# Rezoning Transportation Analysis

Petition Number: #2022-170

Date	Description
02-22-23	First Review (TM)

REZONING PETITION #2022-170
SCHEMATIC SITE PLAN

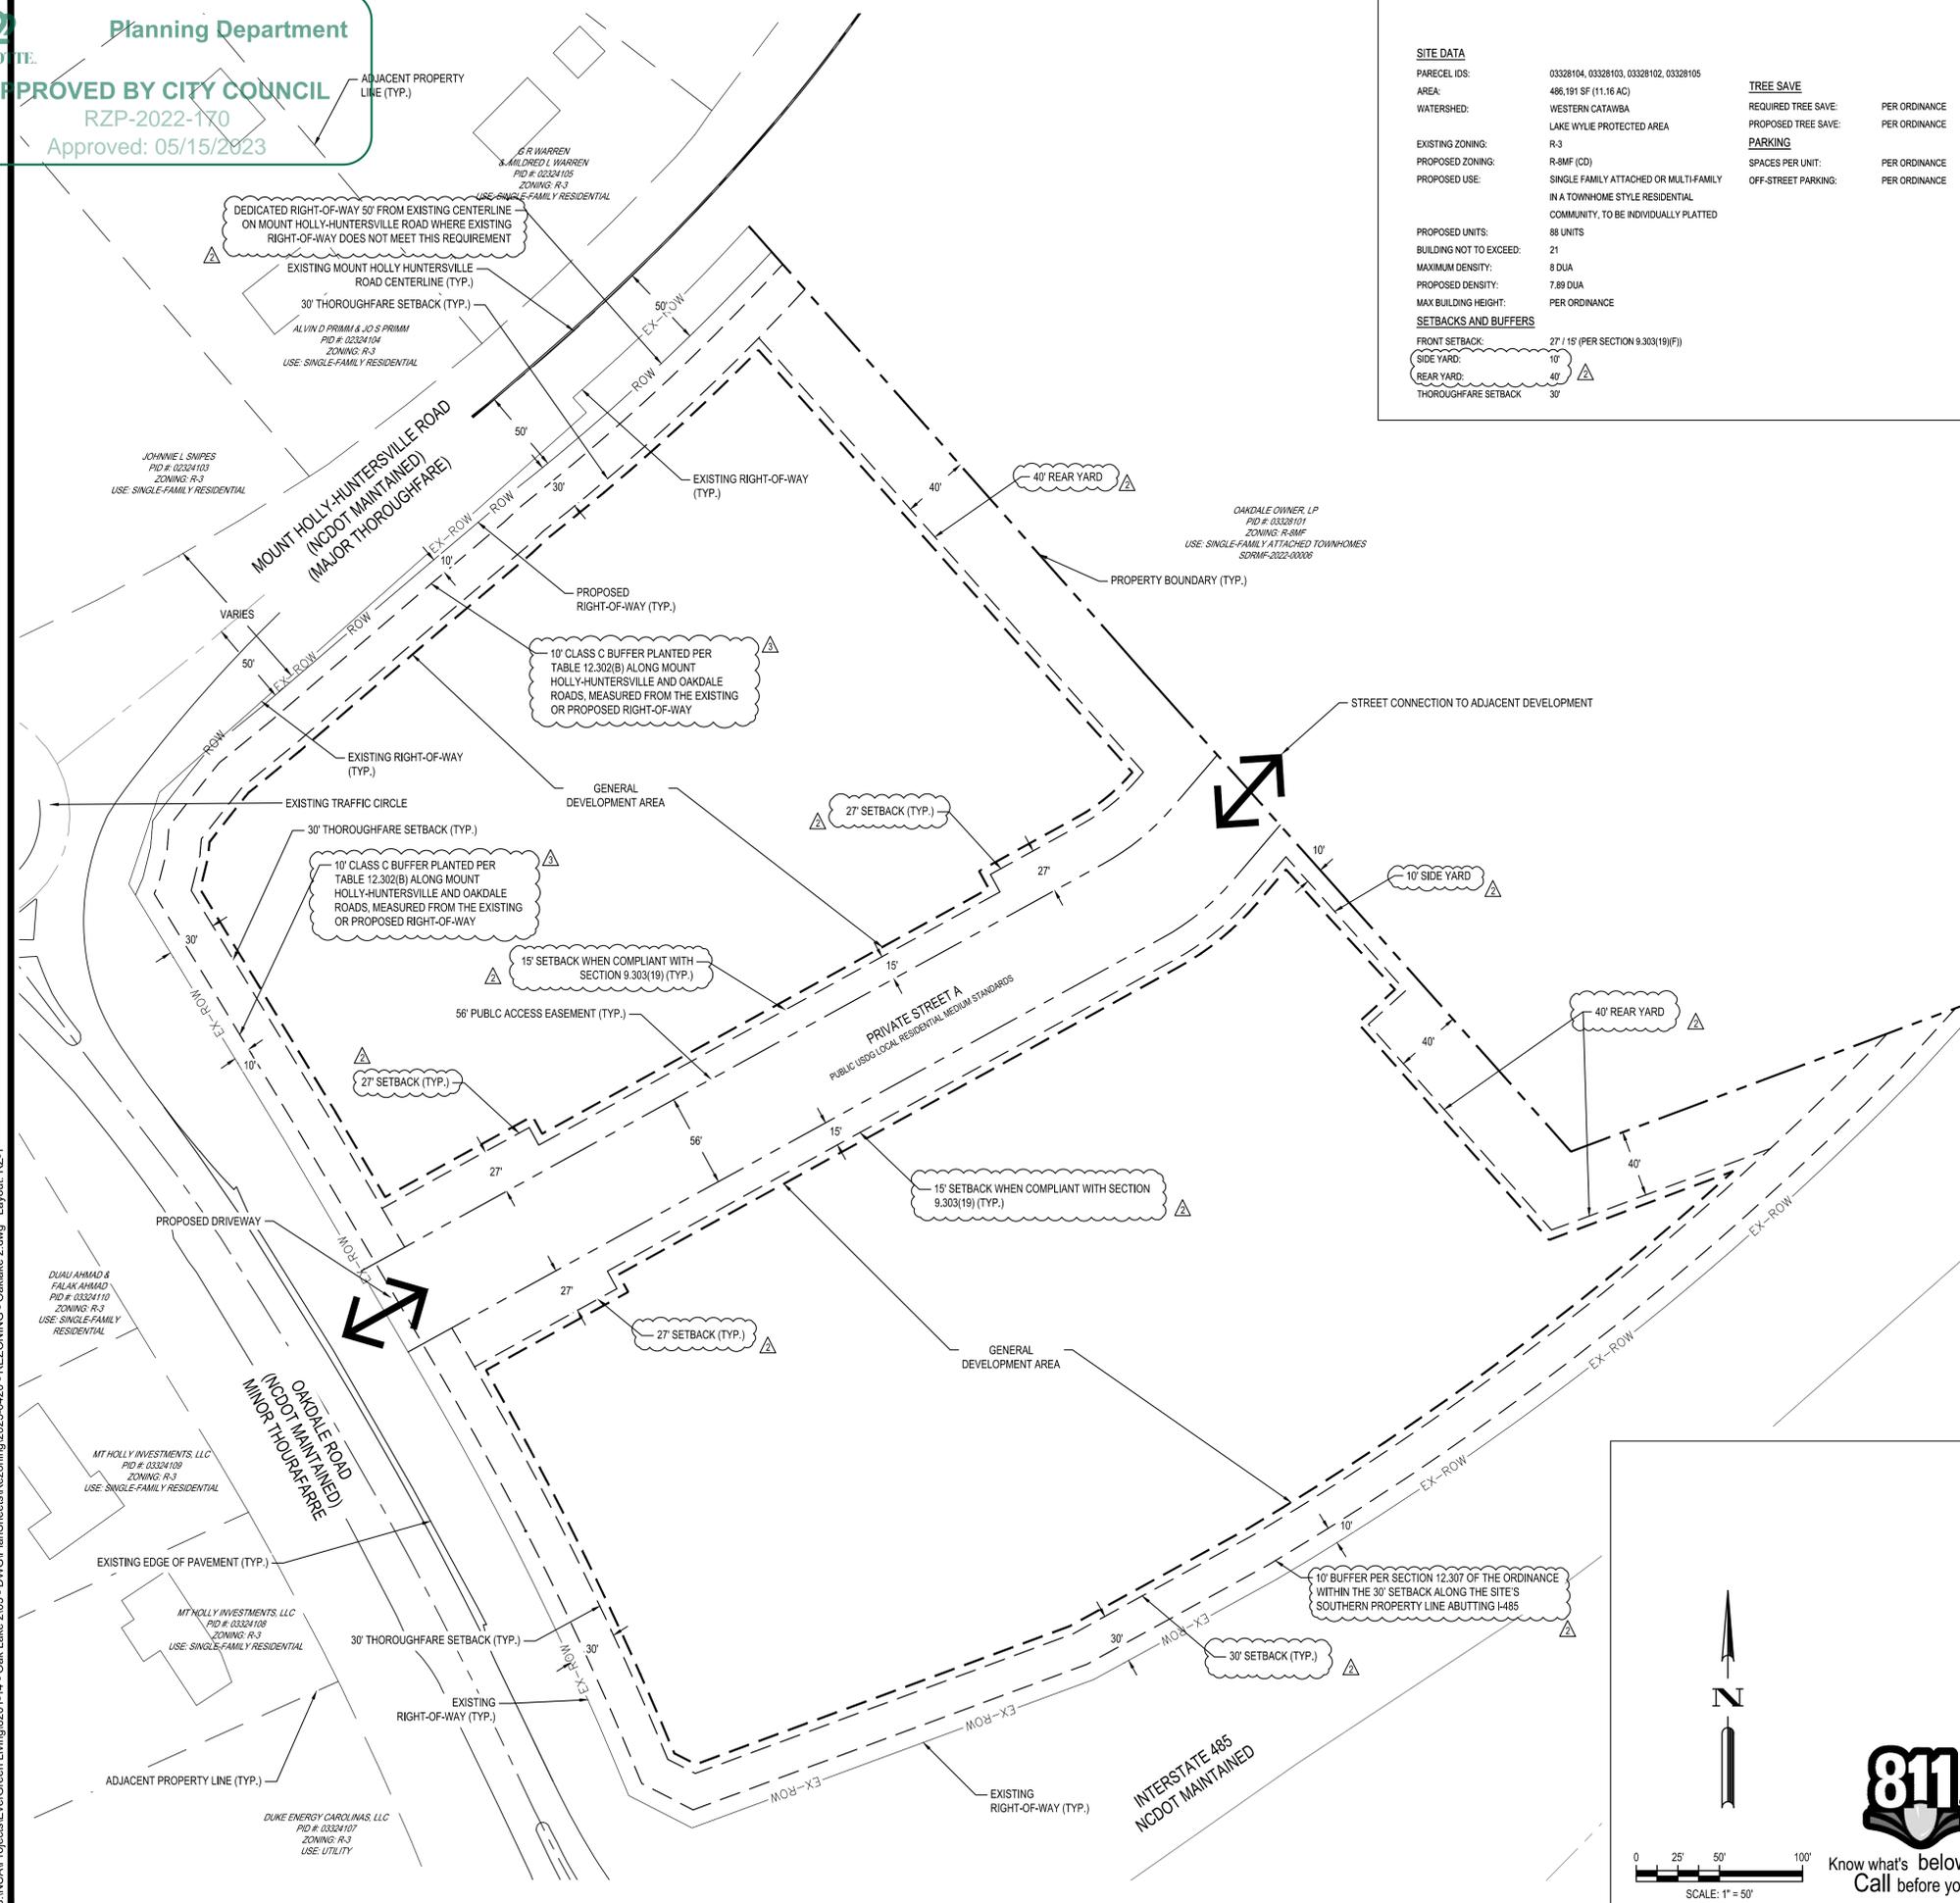
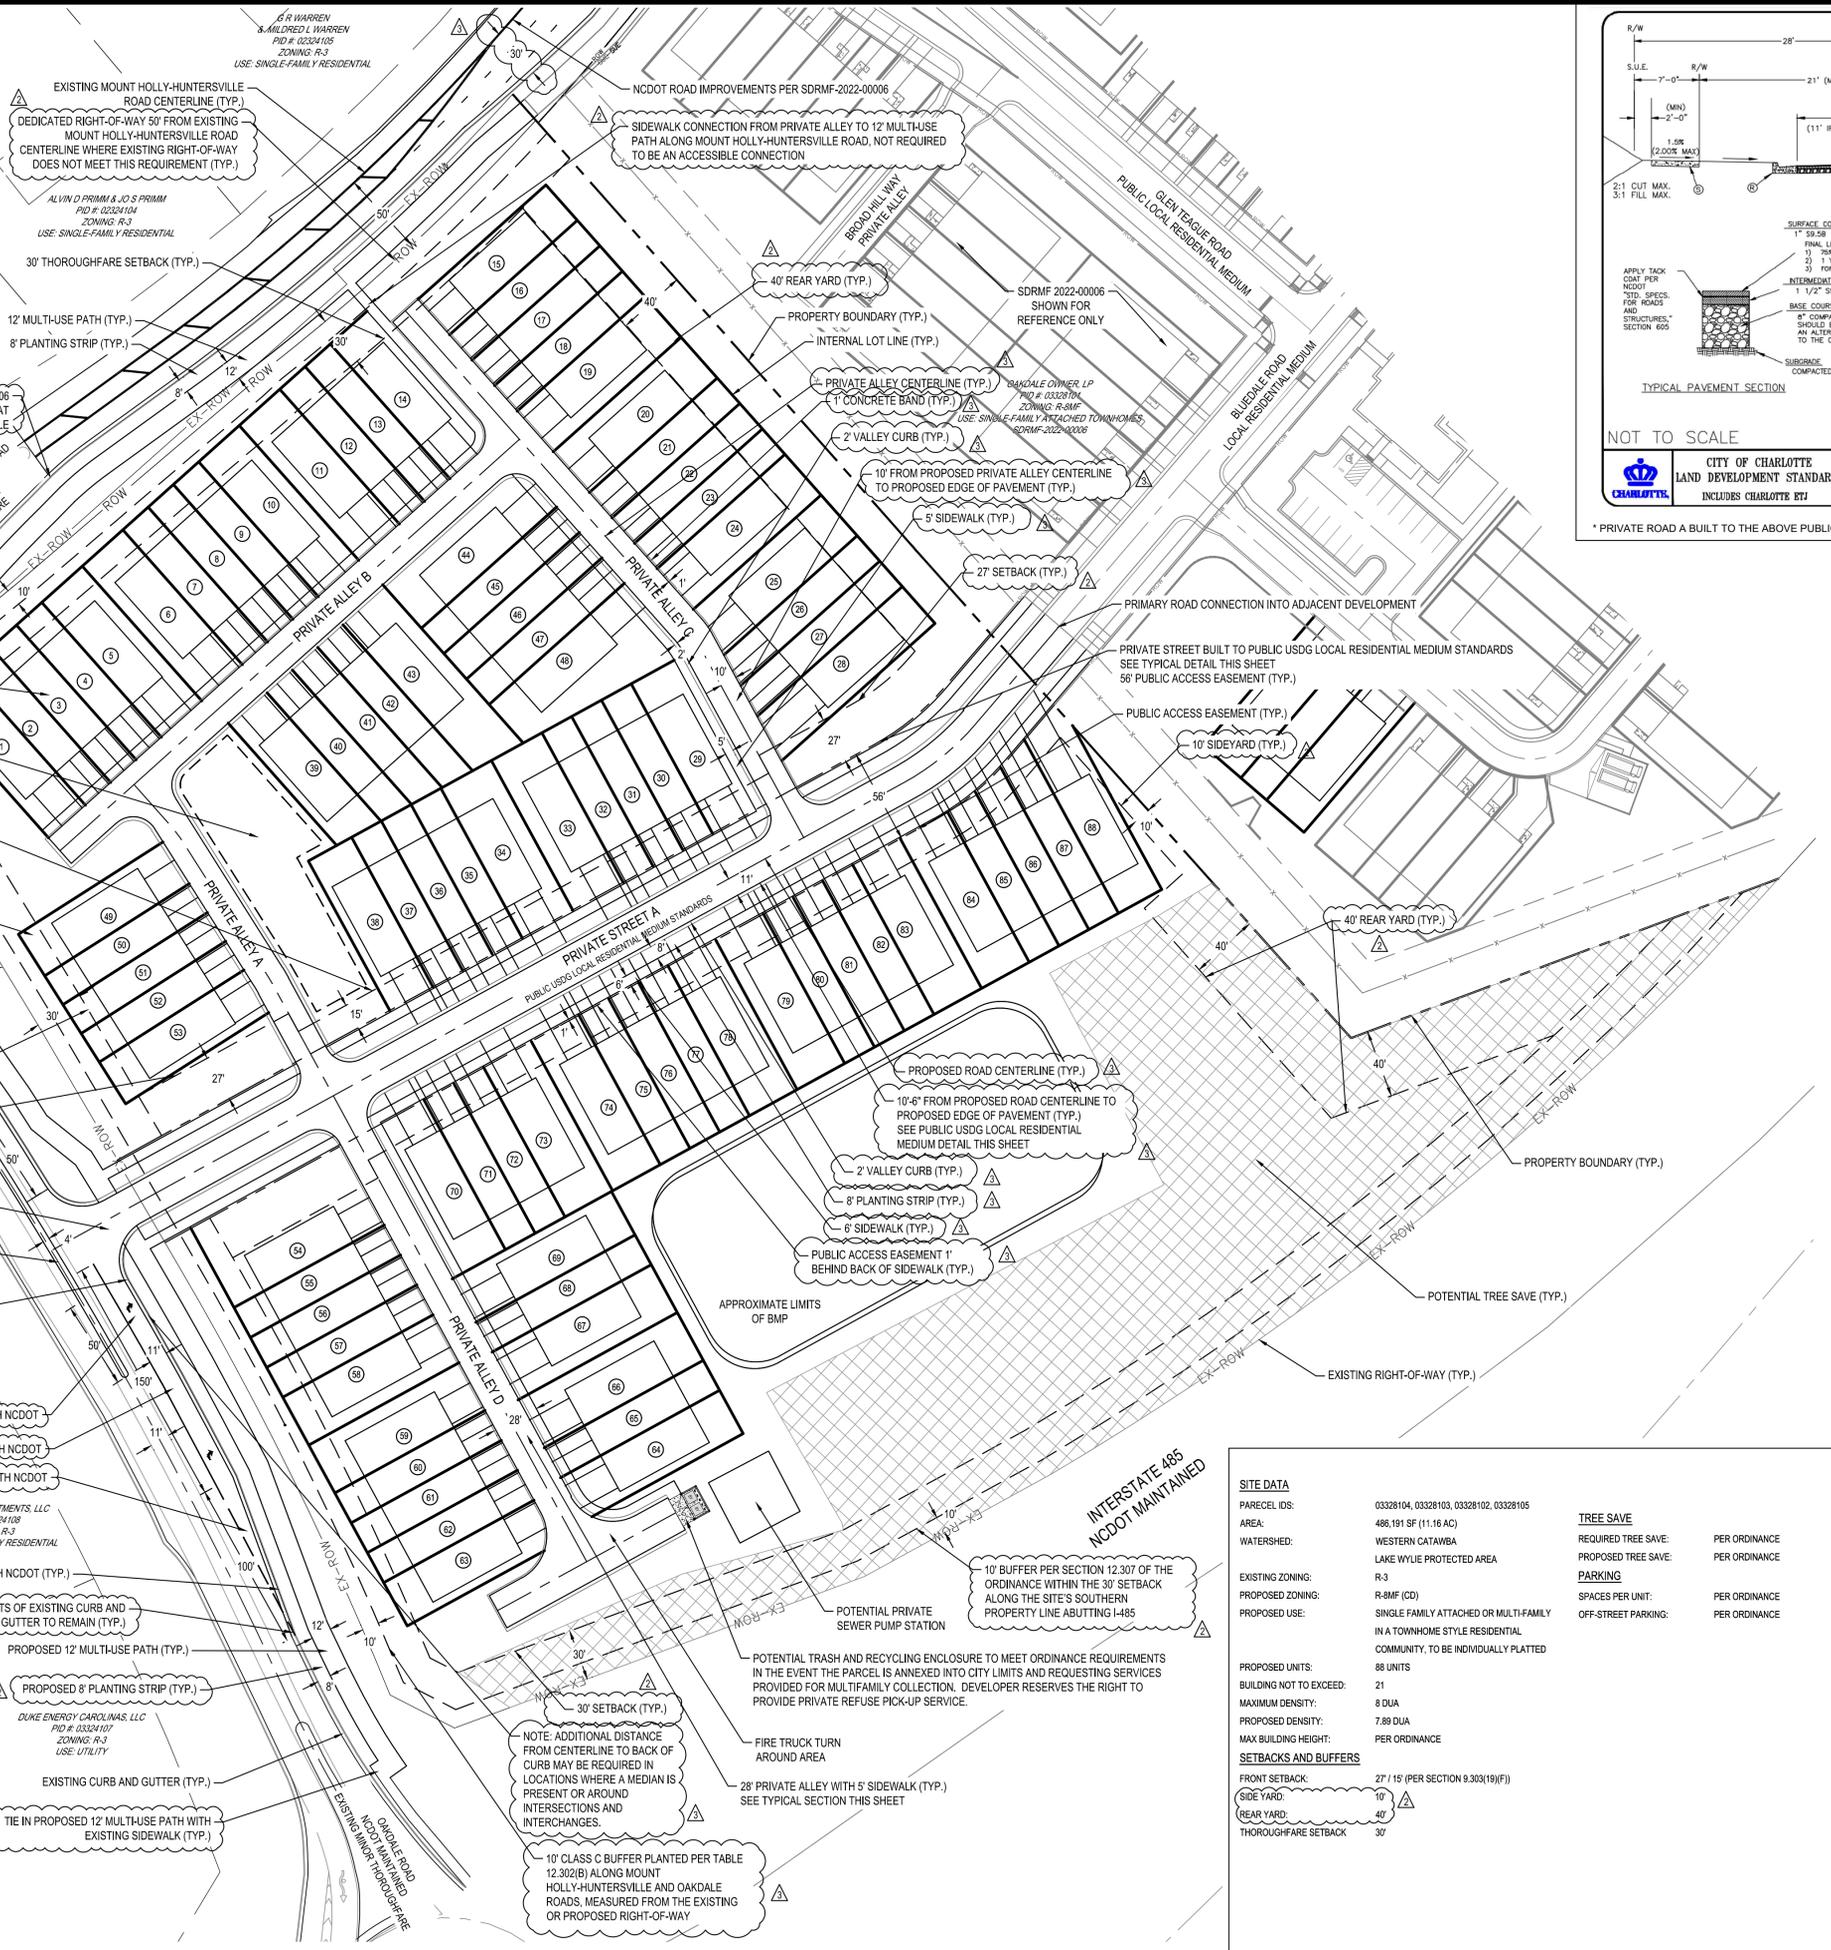
- Mt Holly-Huntersville Road:** Location of curb and gutter to be moved to 30-feet feet from roadway centerline to accommodate the Charlotte Streets Map with a roadway typical section of 4+ Avenue, Shared Use Path.
- Oakdale Drive:** Location of curb and gutter to be moved to 19-feet from the roadway centerline to accommodate the Charlotte Streets Map with a roadway typical section of 2+ Avenue, Shared Use Path.

Label and dimension the curb and gutter from the centerline for each road on the site plan.

- Revise site plan and conditional note(s) to commit to dedicate 50-feet of right-of-way from the Mt Holly-Huntersville Road centerline. The site plan shall label and dimension the right-of-way from the road centerline.
- Revise site plan and conditional note(s) to commit to Private Road A to be a public roadway.

5. Revise site plan and conditional note(s) to commit to restrict Oakdale Drive site access to right in right out by constructing a median that does not restrict access to neighboring parcels in coordination with NCDOT. Median shall extend 50-feet past the site entrance in either direction.

6. Revise site plan and conditional note(s) to commit to widening Oakdale Drive enough to construct a right turn lane into the site with 100-feet of storage in coordination with NCDOT. Site plan shall label and dimension right turn lane. Add a conditional note committing to constructing the right turn lane.

7. Revise site plan and conditional note(s) to commit to construct bicycle facilities by installing a 12' multi-use path on Oakdale Road to meet the Council-adopted Charlotte BIKES Policy. Multi-use paths maintained by the City shall meet ADA/PROWAG requirements. This also matches Charlotte streetscape map.

8. Revise site plan by dimensioning and labeling the internal street infrastructure including curb line, sidewalk, planting strip and Right of way.
9. Add a conditional note specifying "A Right-of-Way Encroachment Agreement is required for the installation of any non-standard item(s) (irrigation systems, decorative concrete pavement, brick pavers, etc.) within a proposed/existing City-maintained street right-of-way by a private individual, group, business, or homeowner's/business association. An encroachment agreement must be approved by CDOT prior to construction/installation. Contact CDOT for additional information concerning cost, submittal, and liability insurance coverage requirements."
